Our Ref: 1-046/001
03 February 2021

RE: NORTHAW HOUSE, HATFIELD – RESPONSE TO HERTFORDSHIRE LEAD LOCAL FLOOD AUTHORITY CORRESPONDENCE (REF; 6/2020/3439/COND, DATED 01 FEBRUARY 2021)

We have now reviewed David Uncle (from Hertfordshire LLFA) comments as provided under correspondence 6/2020/3439/COND, dated 01 February 2021. Each of the queries raised and our responses to each query is provided below;

DRAWING TITLE: **PROPOSED POND SECTIONS**

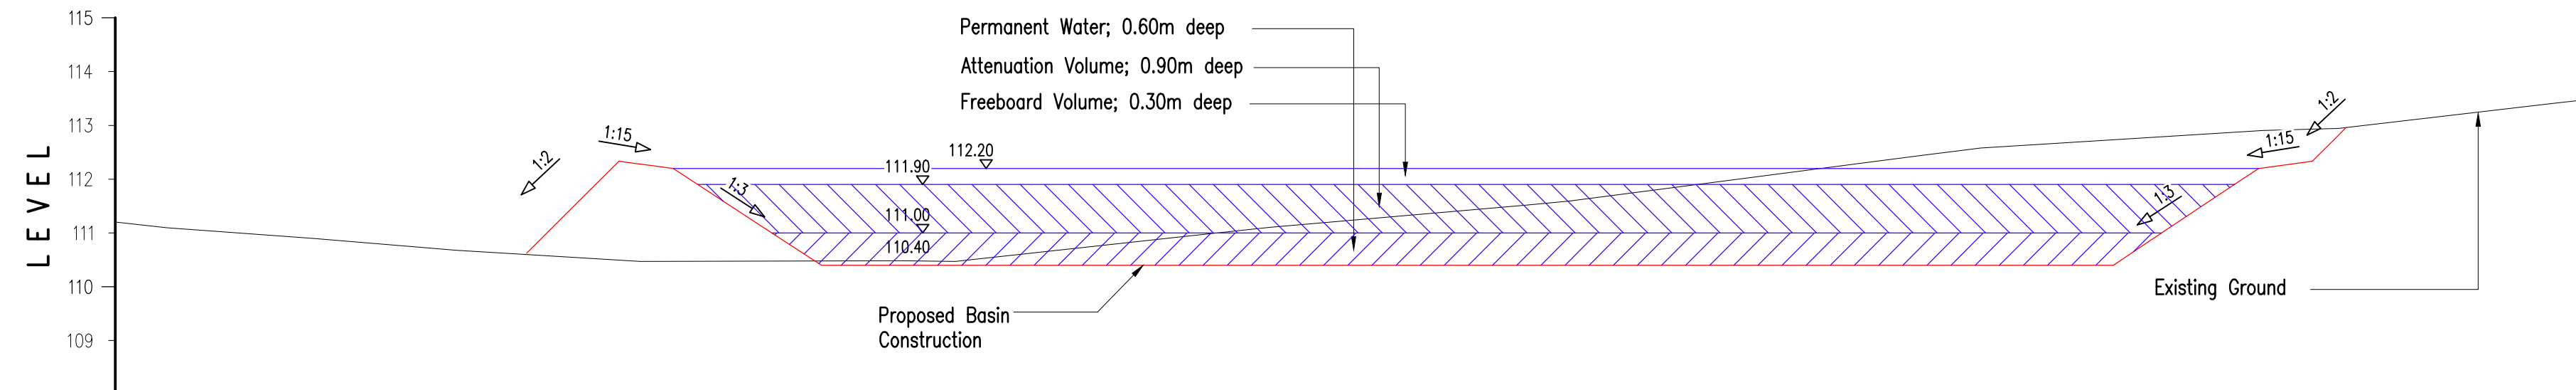
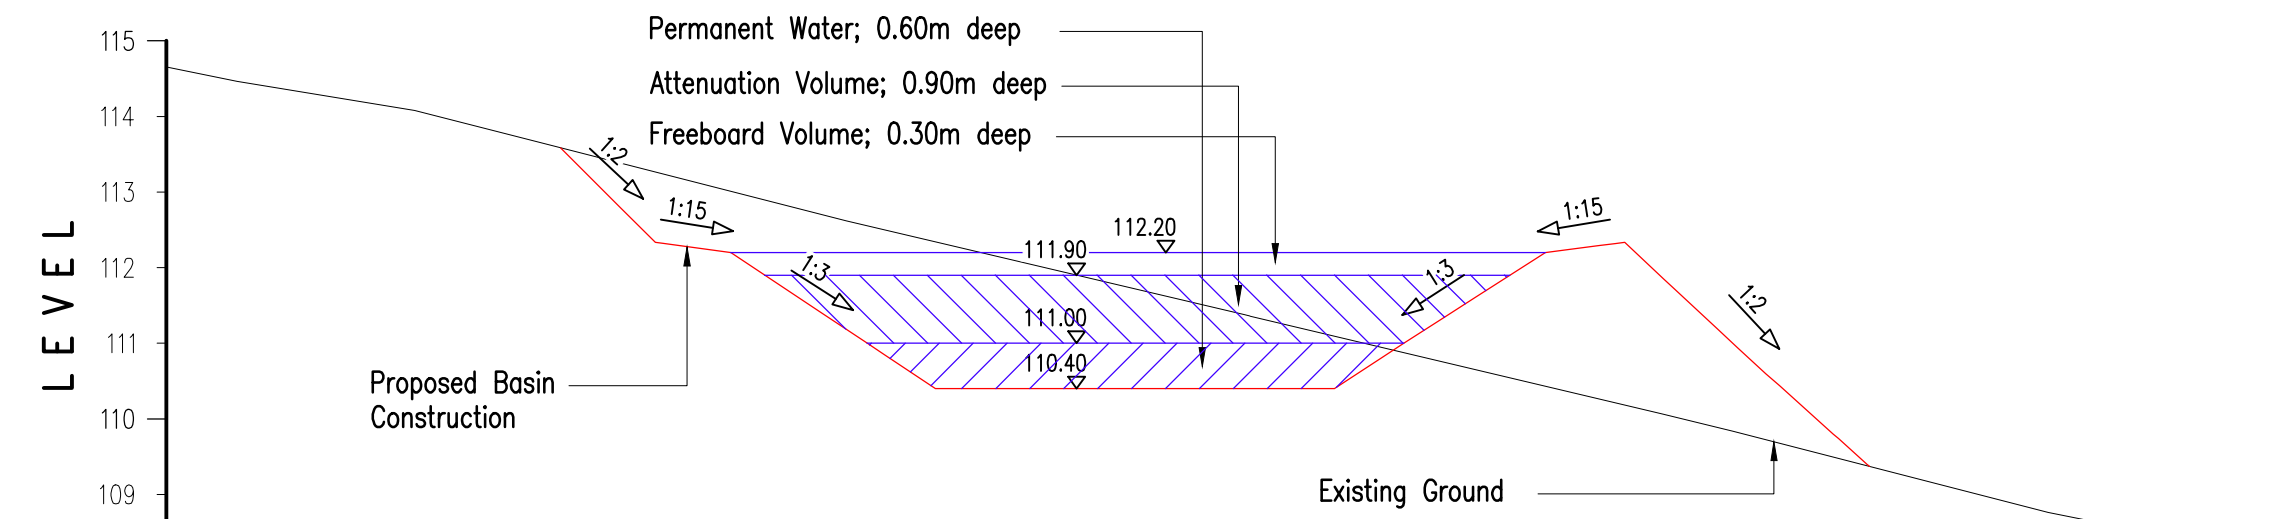
1. *“We require half drain down times to be less than 24 hours or evidence that the proposed network can manage for a 1 in 100 + 40% climate change storm followed by a 1 in 30 year event”*

It can be seen from the Causeway FLOW results (attached to this letter) that the storage volumes within the pond for the 30+0%cc event and 100yr+40% climate change event are as follows;

- 1:30yr storm event = 385.35m³
- 1:100yr+40%cc = 799.13m³

Total = 1,185m³

There is a total of 1,305m³ available within the pond, allowing ample storage for both the 30+0%cc event and 100yr+40% climate change to occur consecutively.

Trapped Gully Detail (1:20)

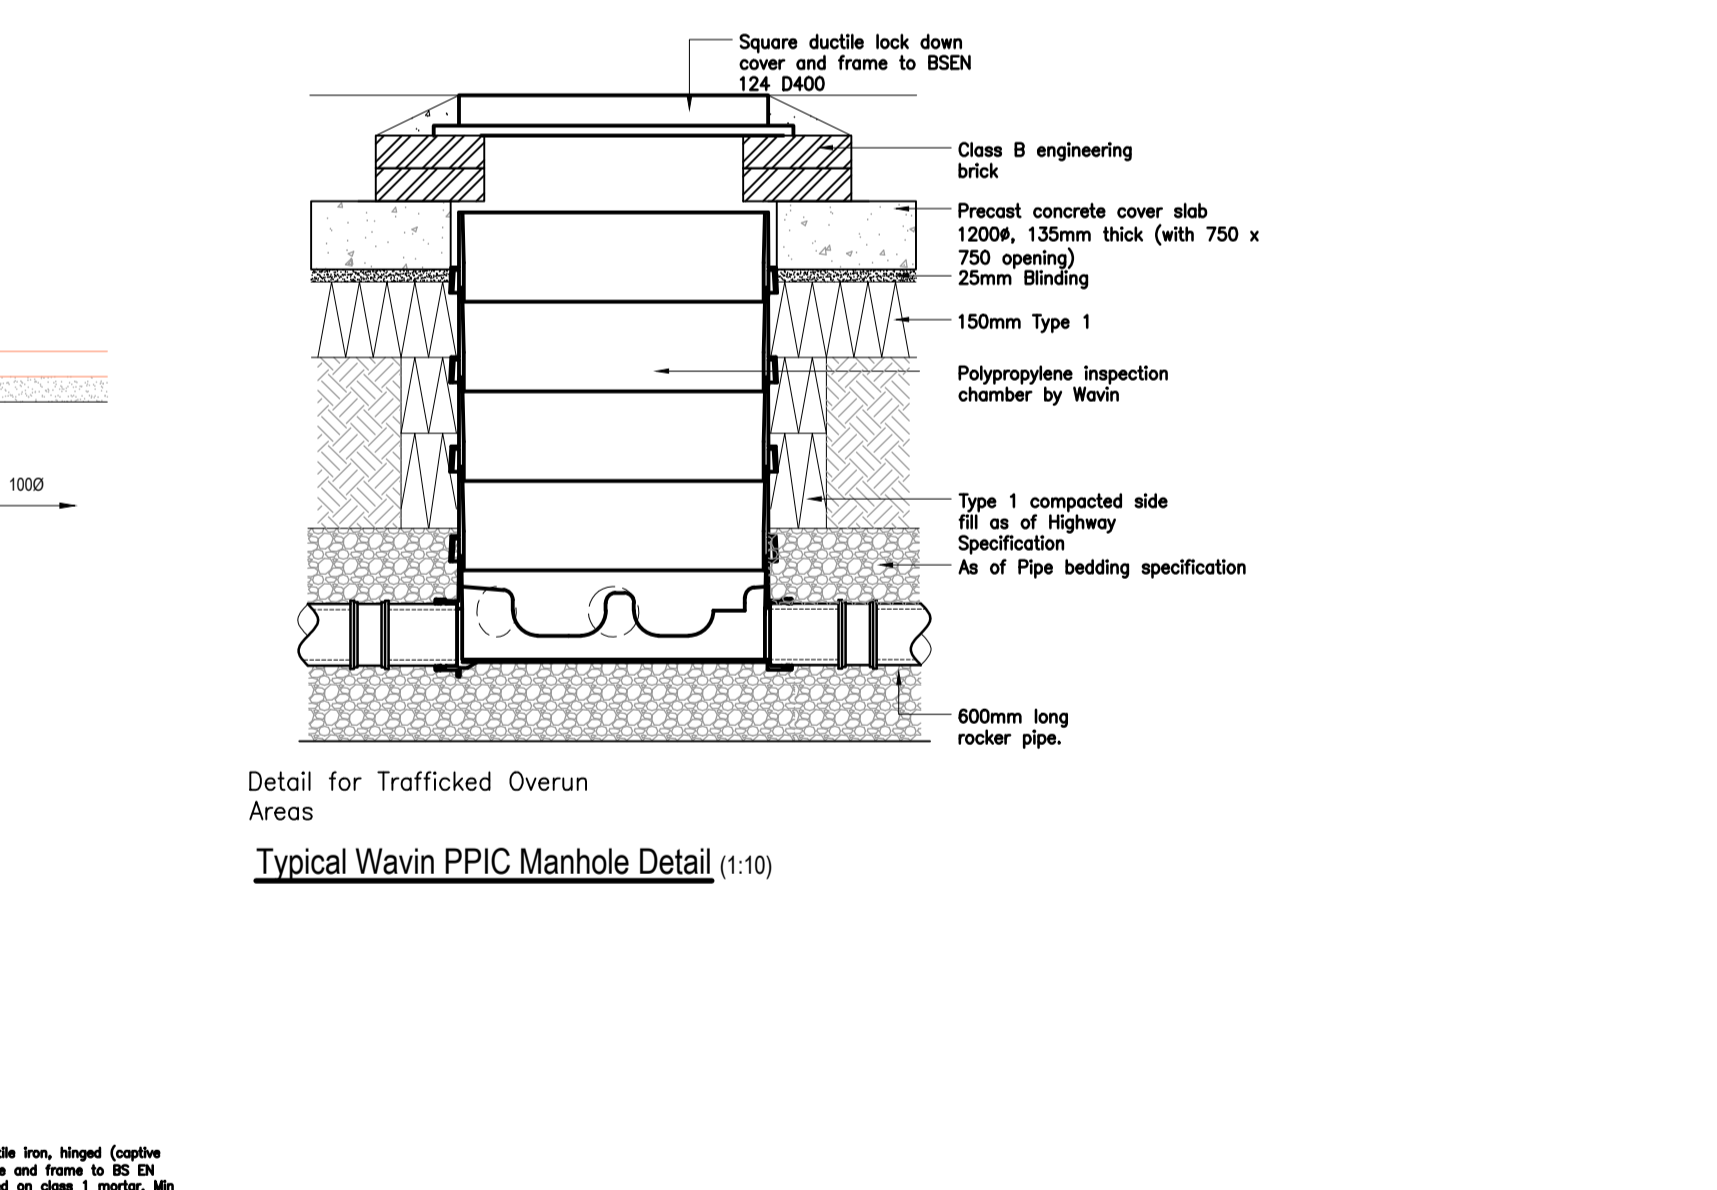
2. *“We also note the addition of surface water pipe runs in the eastern road (pipes 12.00 – 12.001). Please could the applicant clarify how run off from this part of the system will receive SuDS management and treatment before entering the pond”*

As of the SuDS Manual (C753) guidance, the access road would fall under a *low* pollution risk area.

Based on the above the access road discharging directly into pipes 12.000 & 12.001 which in turn discharge to the pond is acceptable in accordance with best practice contained within the SuDS Manual (C753). Indeed, the mitigation provided within the pond alone is far in excess of the minimum requirements.

The swale to the north of the access road will not be positively drained. The reason for this is due to the swale going against the natural topography resulting in excessive invert depths (around 3m deep) resulting in large earthworks. The swale will still provide an exceedance flow function however and hence why it is still shown on the plans. The road area in question will drain via a trapped gully system connected to pipes 12.000 and 12.001.

Section C-C - Typical Dry Swale Detail (1:20)

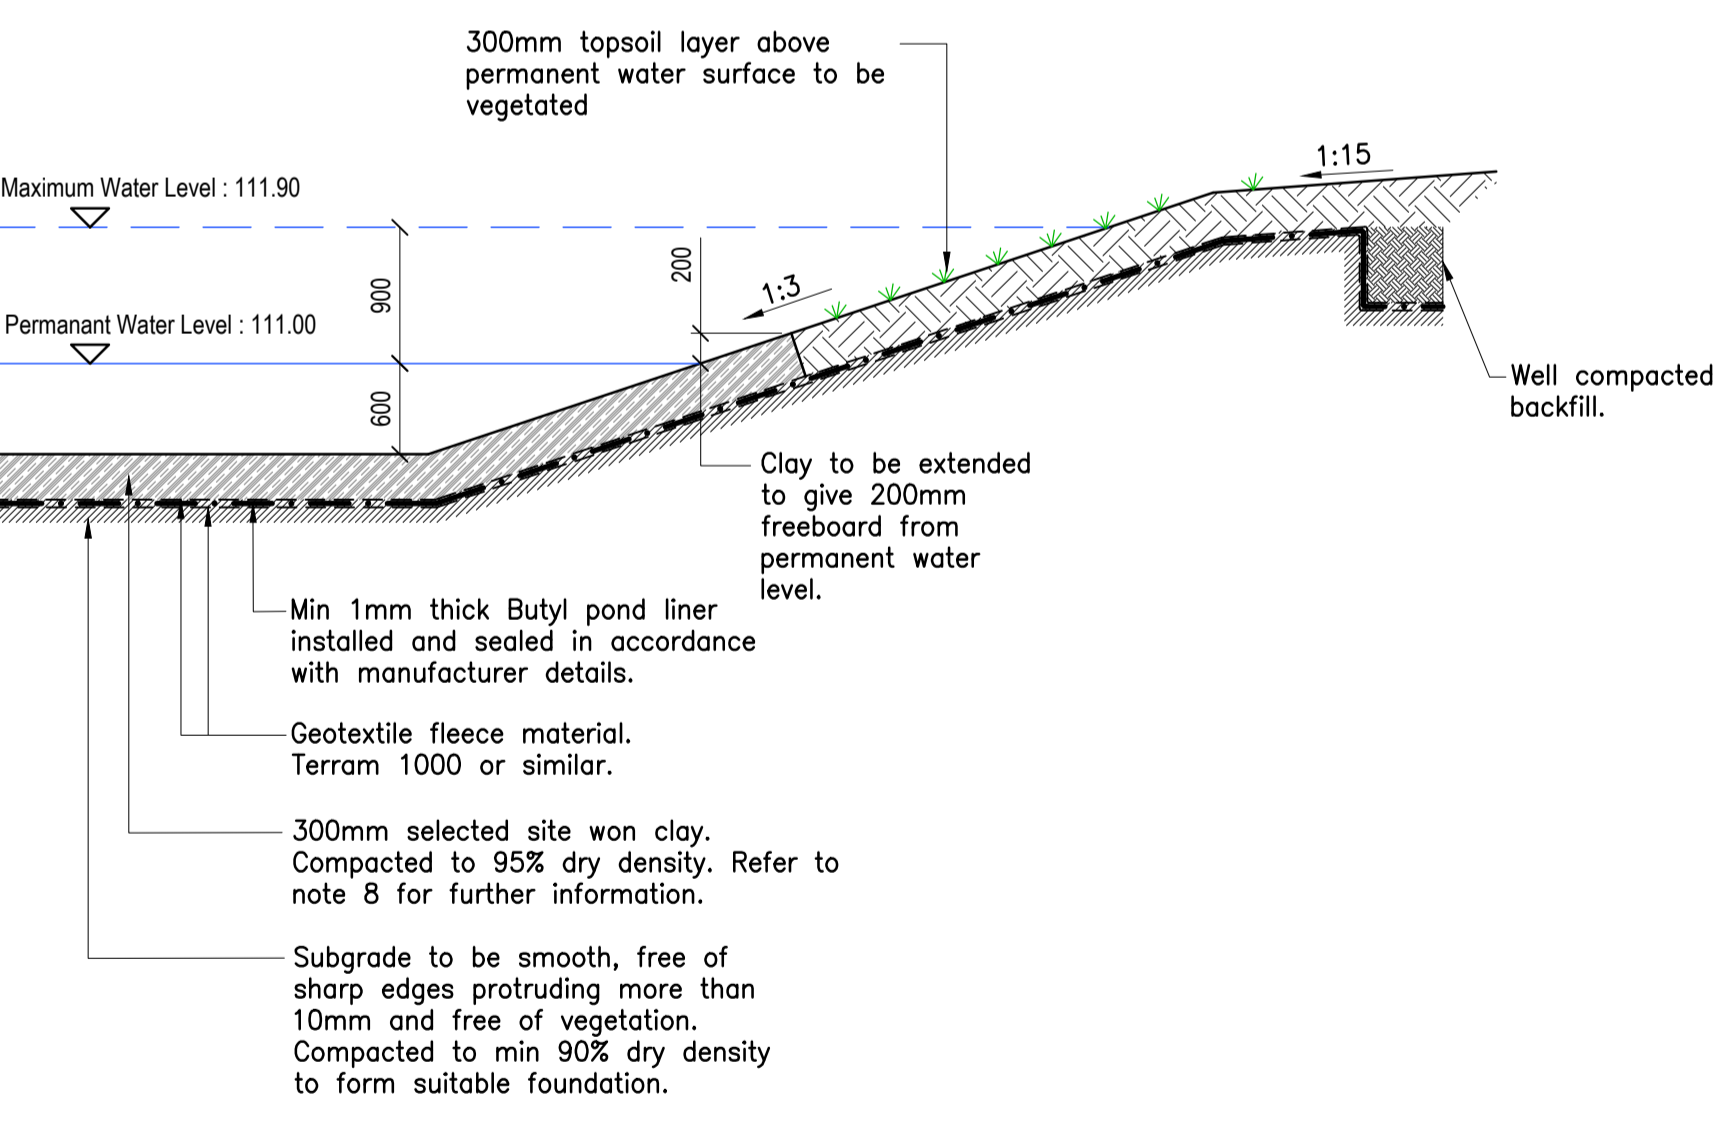
3. *“Please could the applicant also clarify how the Swale North of this eastern Rd connect to the wider drainage network as we understand the previously approved swale was to connect to the site network at the western end of the swale, but this is no longer indicated”*
